From: Zac Denton
Sent: 29 July 2019 09:40
To: MSN Service [REDACTED]
Subject: RE: M/45/19/DOC

Engineers Comments Regarding Condition 5- Surface Water Drainage

No. 93/16/05 X

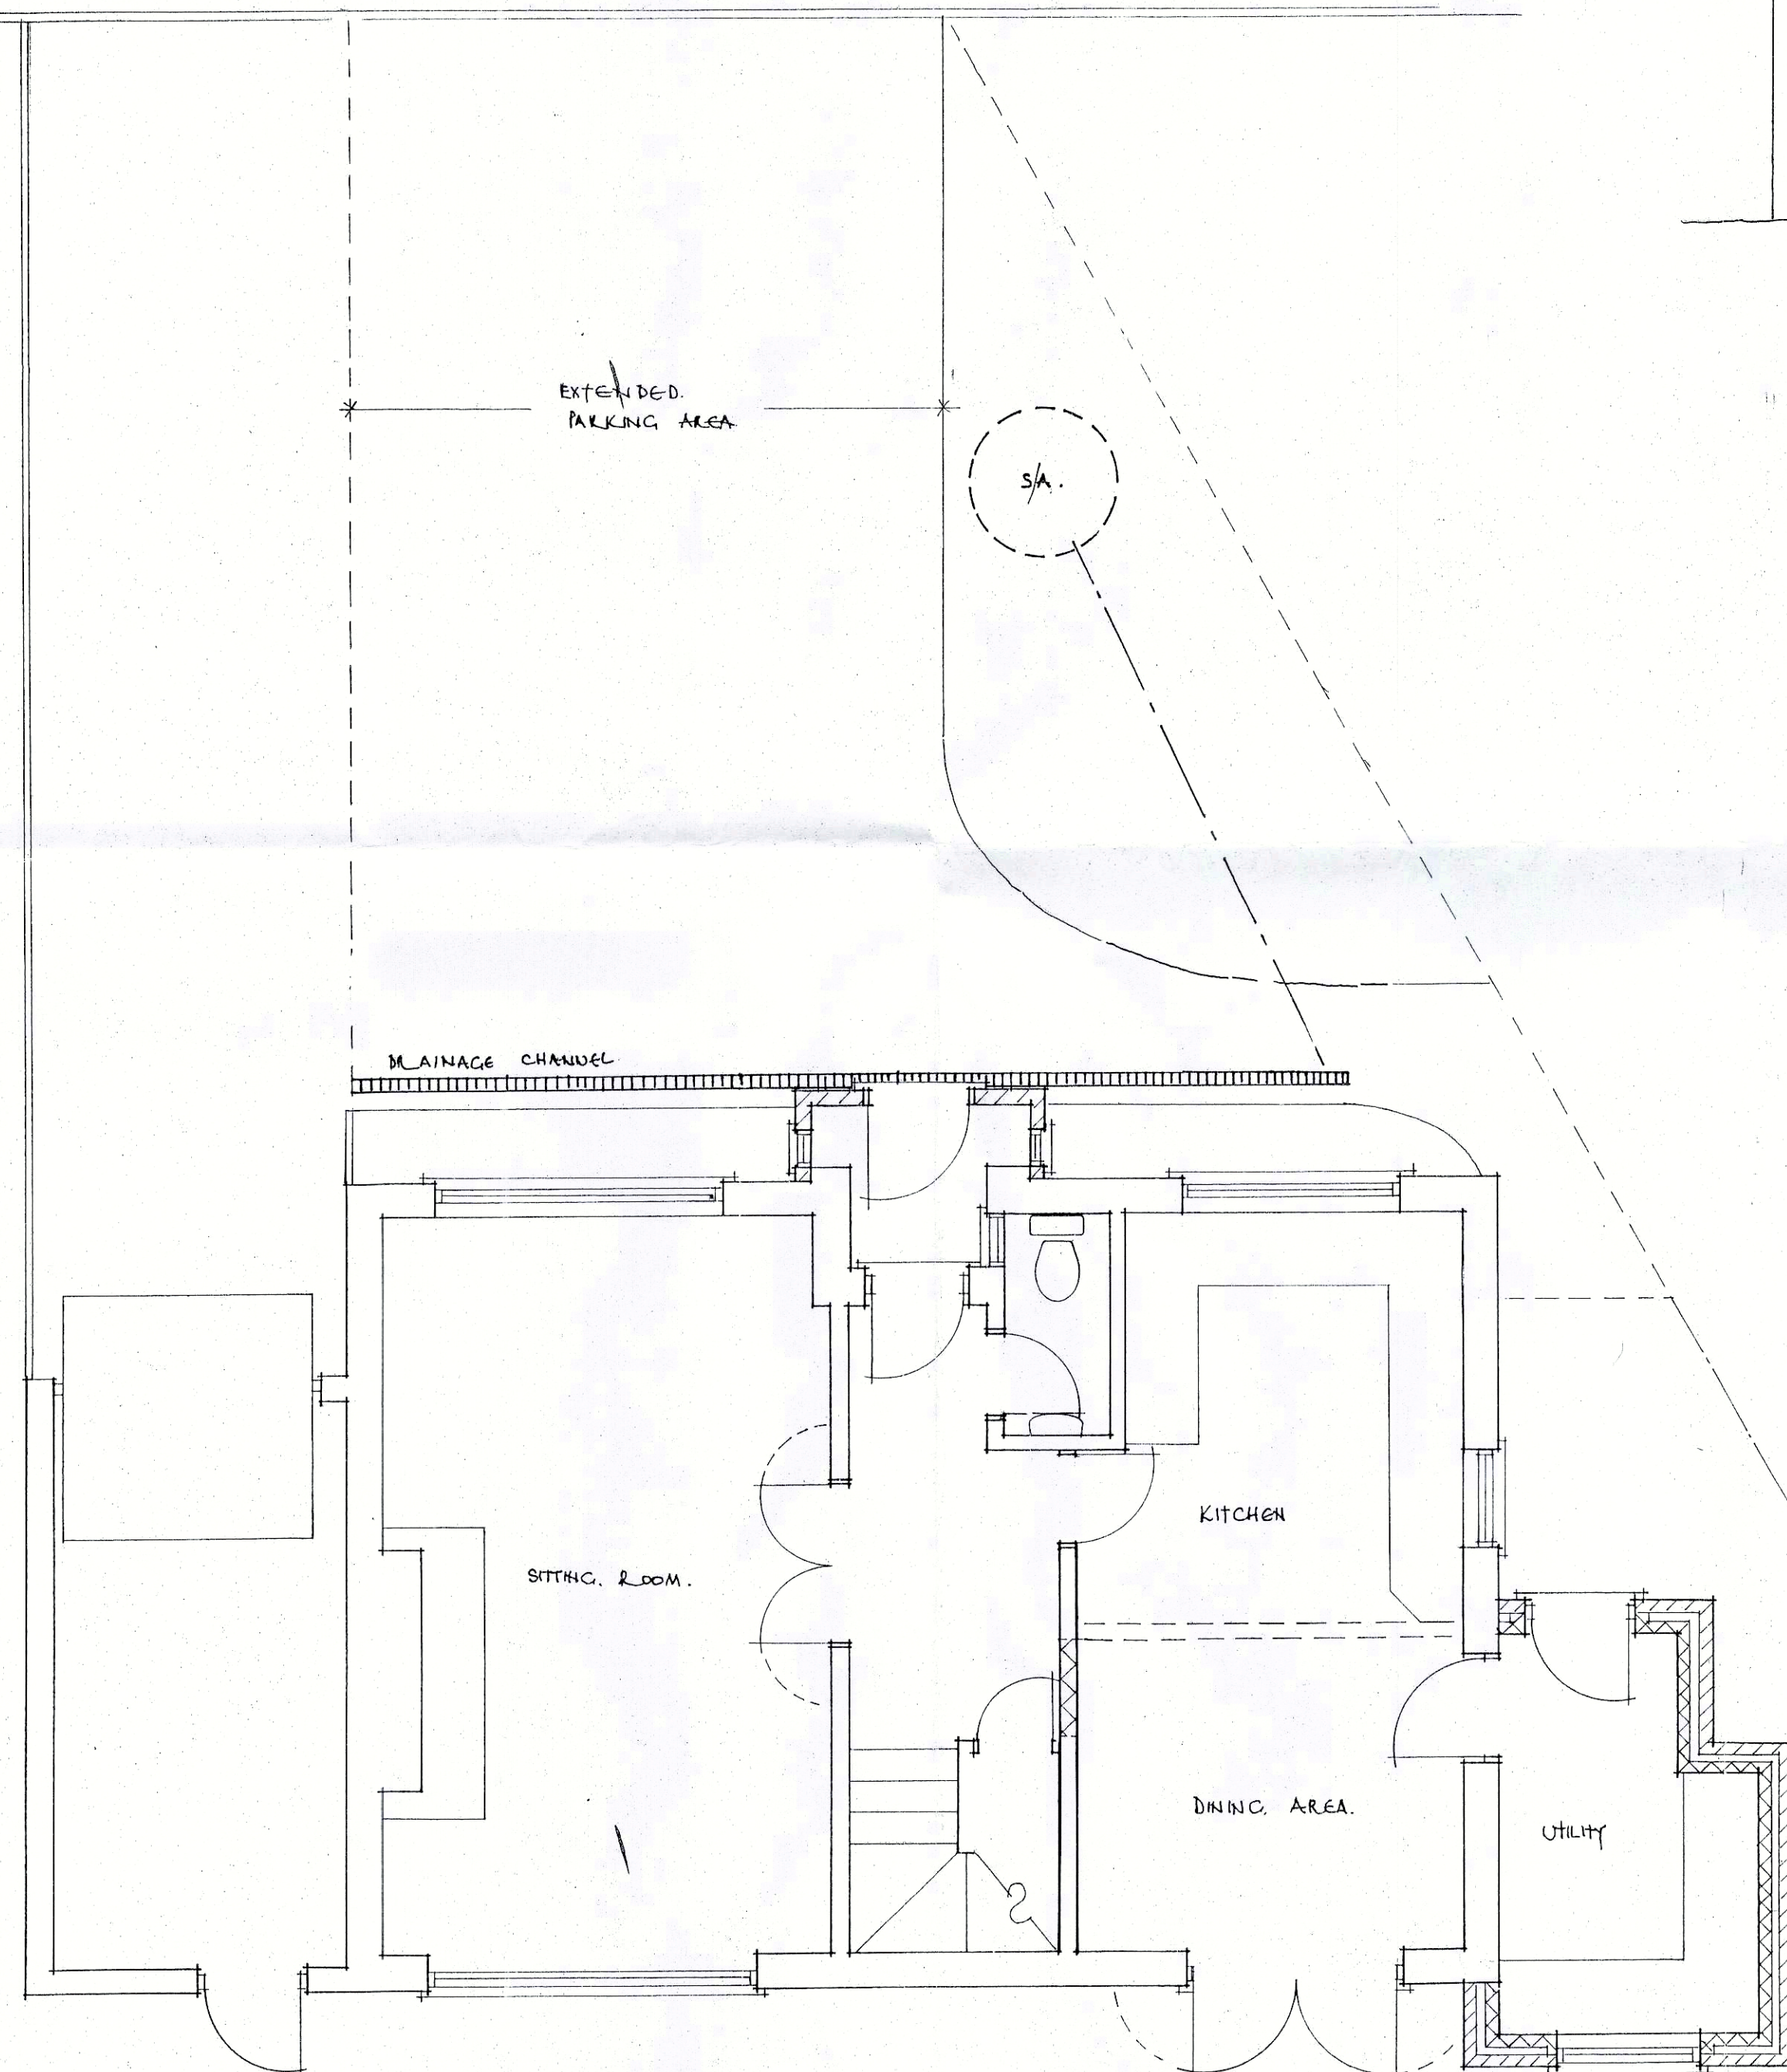
No groundwater monitoring, infiltration testing, calculations or details have been submitted.

Please can the applicant complete our drainage checklist (attached) and submit this with the supply of further information.
